Property and Services | Field Services**Telephone: (02) 9620 0104****Your Reference: SSD 7564**

14 June, 2016

Re: SSD 7564, Proposed Warehouse and Distribution Facility – Notice of Exhibition**Lot 2, Horsley Drive Business Park (Part Lots 24/25 in DP 13961, Part of Lot 1 in DP 103699 and part of Lot 10 in DP 879209)**

SITE PLAN

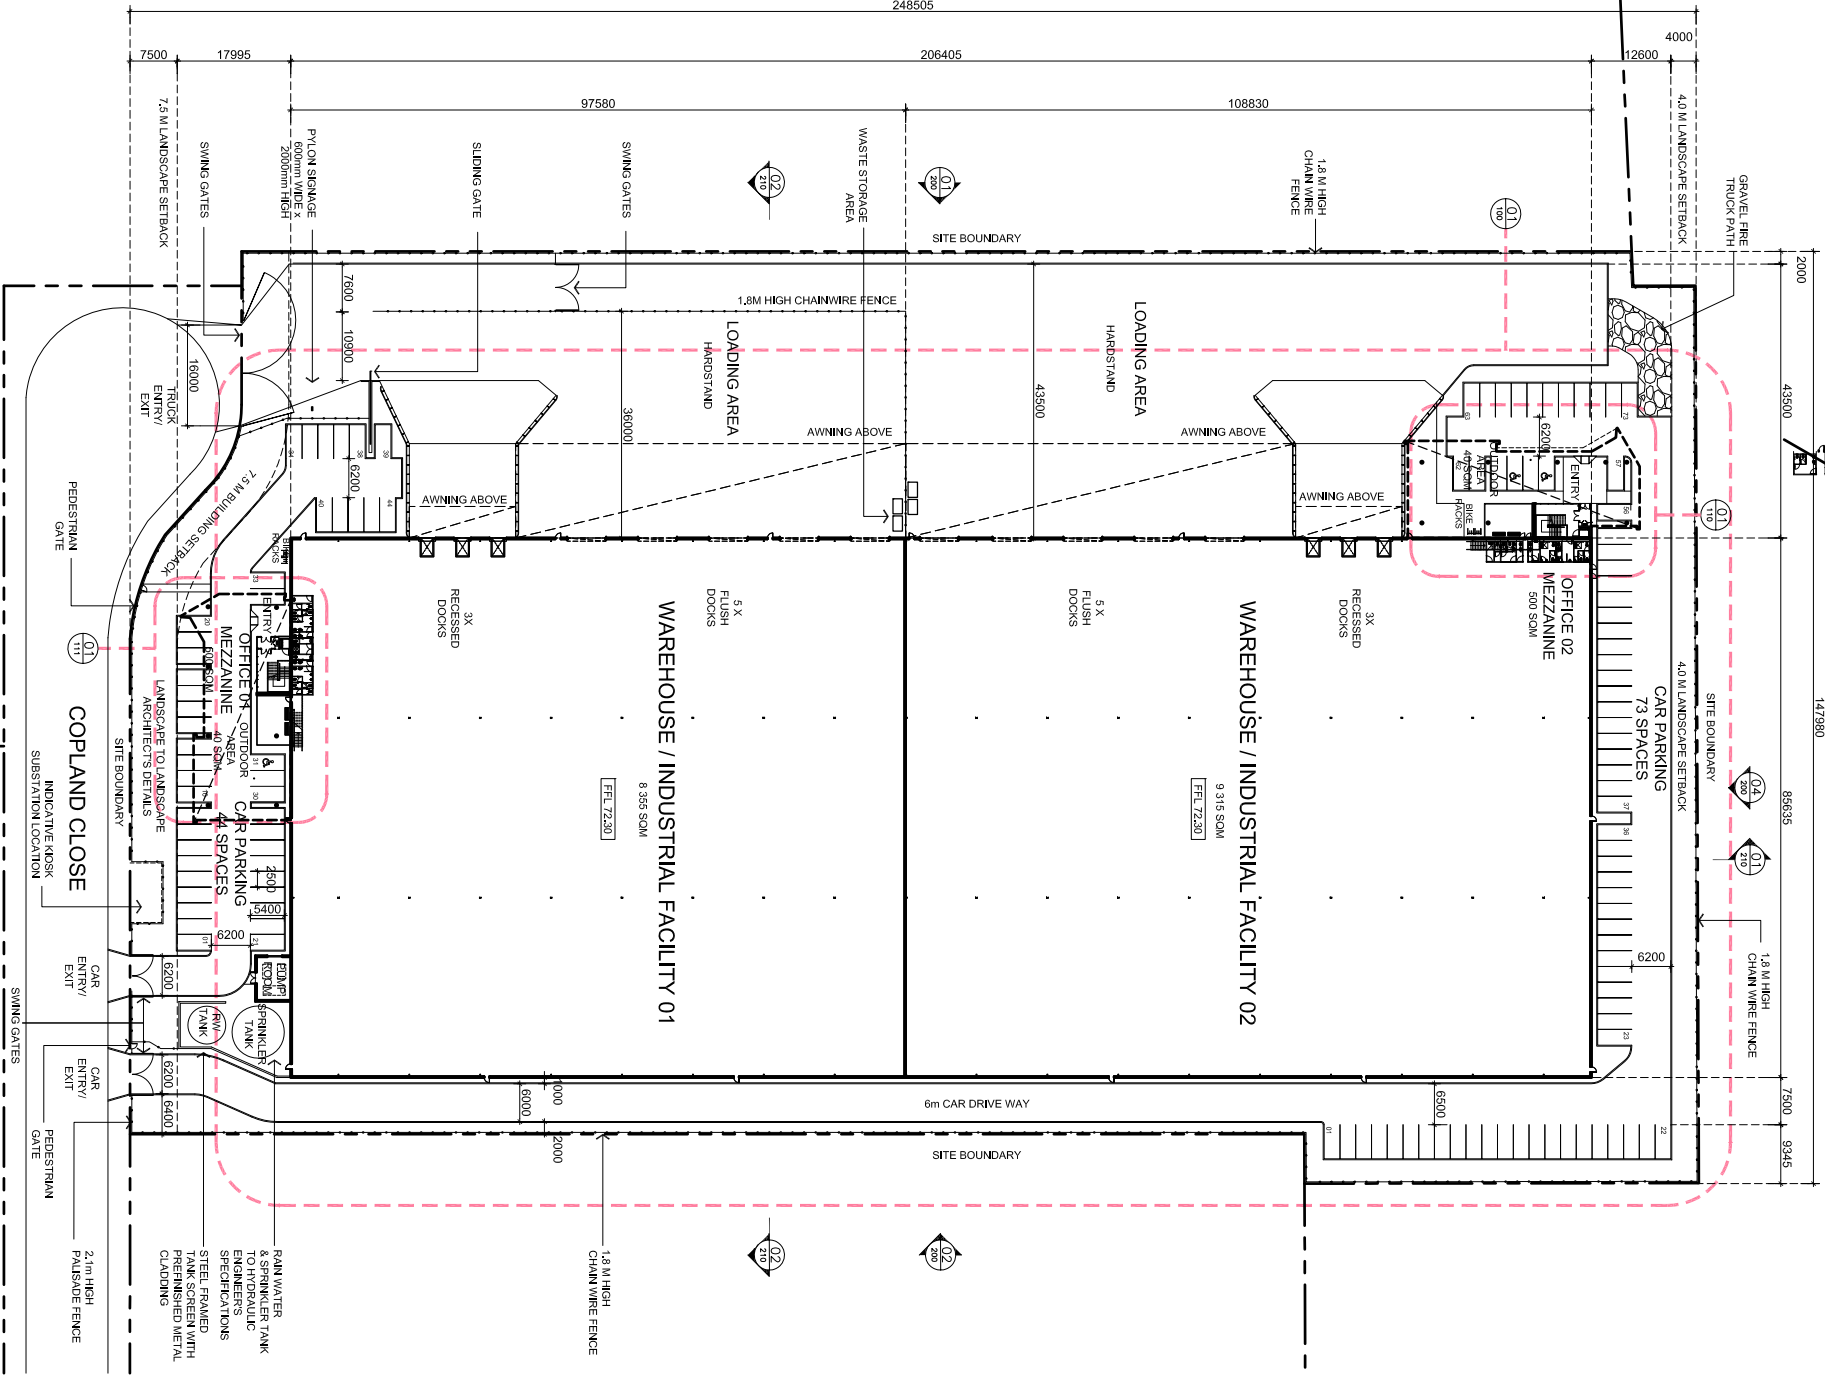
1. No structures (temporary and/or permanent) including car parking areas are to be located within TransGrid's easement. This easement still has the same protective covenants and legal rights even though no physical transmission line is currently in operation at this time.

TransGrid does not endorse nor encourage people to congregate on the easement and/or under the high voltage transmission lines.
